From: Carol Reynolds
Sent: 21 September 2017 17:16
To: Planning.Responses
Subject: FW: Planning Consultation on: R/184/17/PD

Environmental Health Comment:

Registered: 18th August
2017
Site Address: 51 Sea Lane Rustington BN16 2RQ
Grid Reference:

Description of Works: Notification for prior approval under class C for a change of use from a shop (Class A1) to a restaurant/cafe (Class A3)

**APPENDIX ONE:
DRAWING SHOWING EXTERNAL EXTRACT AND VENTILATION EQUIPMENT PROPOSED**

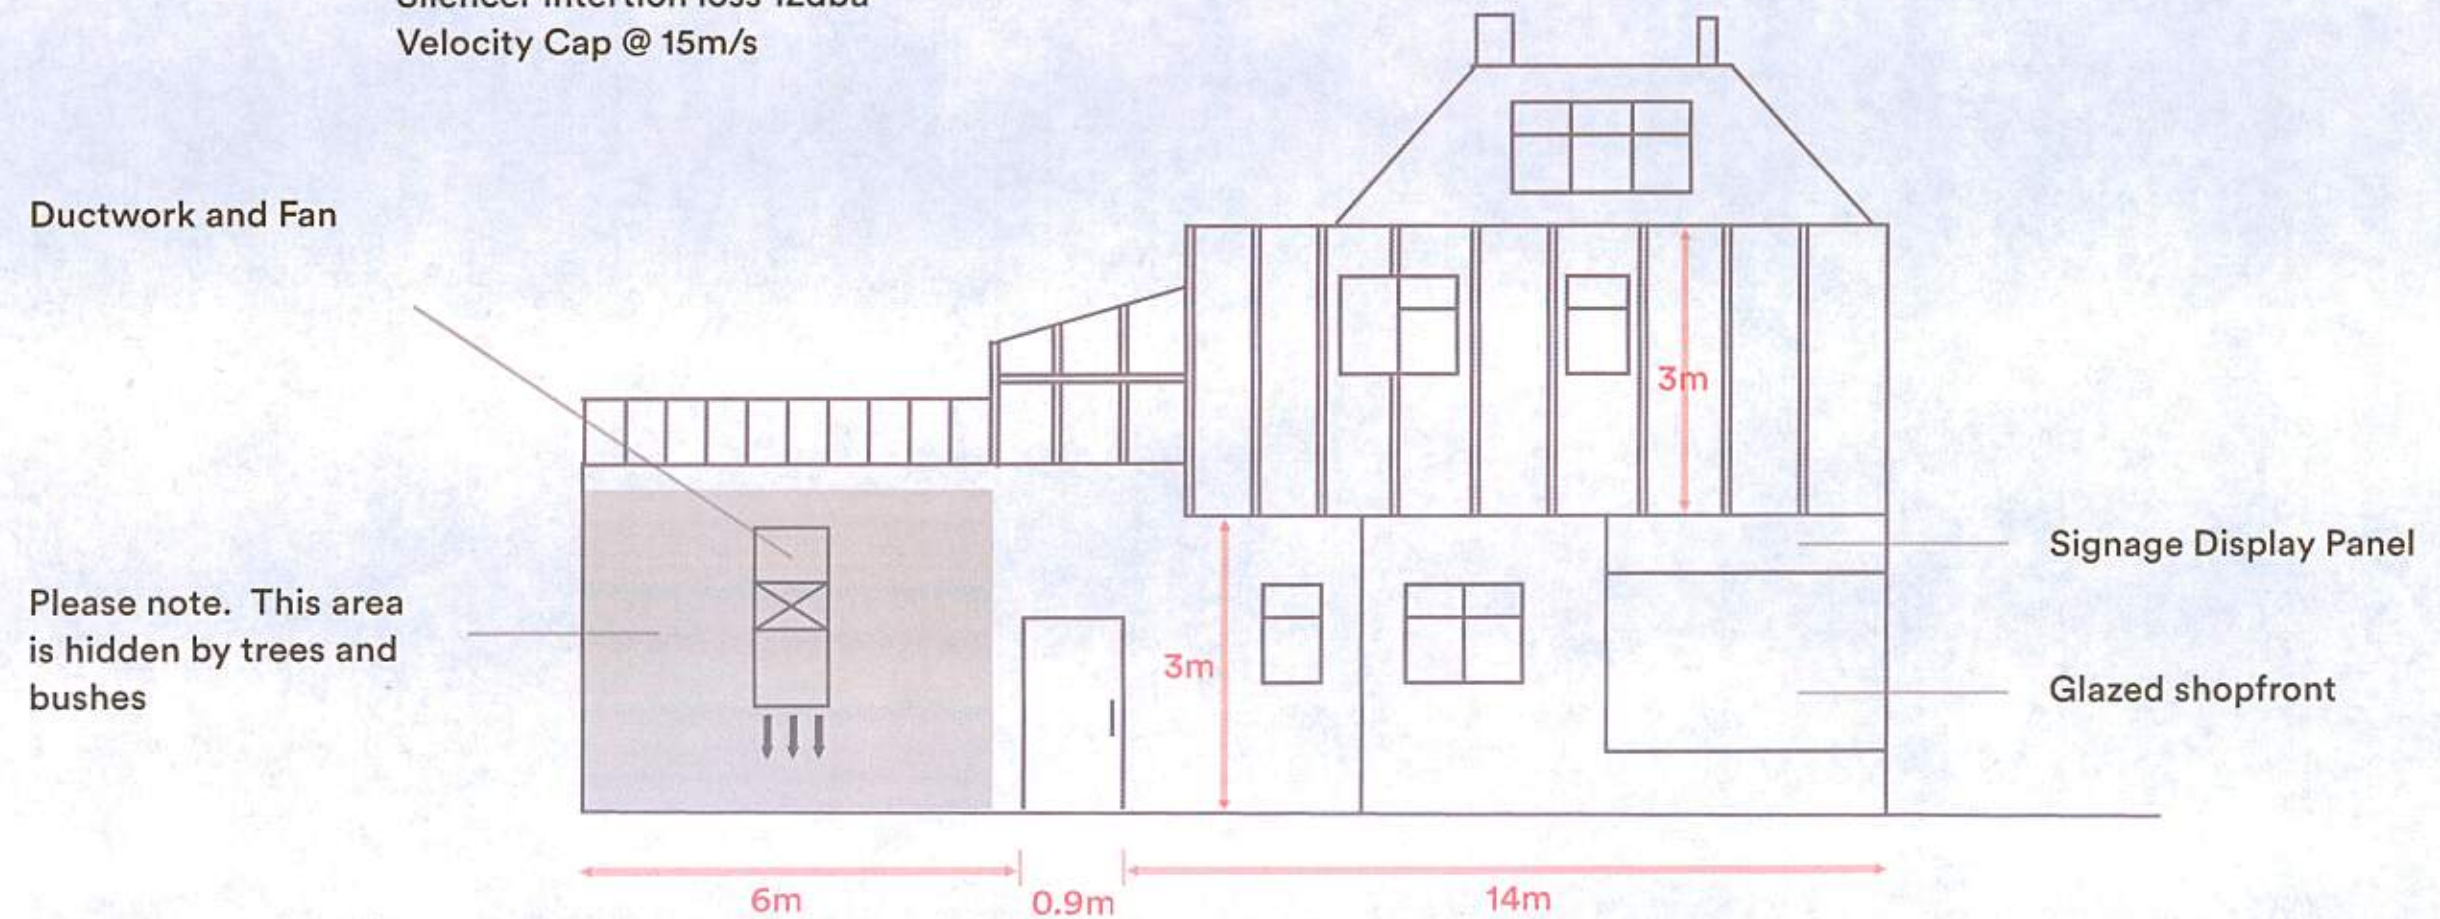
Unfortunately, there is insufficient information provided with this application to allow me to form a proper opinion of whether noise, or odour nuisance may be anticipated in this case. I request a suitable Noise Assessment Report to be provided for any ventilation system and fuller detail of odour/fume control measures designed to prevent nuisance as described.

Noise (Acoustic report) Before the development commences, the applicant shall submit a report, prepared in accordance with the provisions of BS4142 to predict noise levels at the nearest noise sensitive location from any mechanical exhaust system that may be put in place.

Air (Ventilation equipment) Equipment detailed to discharge odours and fumes from the cooking process shall have been agreed, installed and be in full working order to the satisfaction of the Local Planning Authority. Please provide detail of abatement equipment, type of cooking to be carried out, and patron numbers.
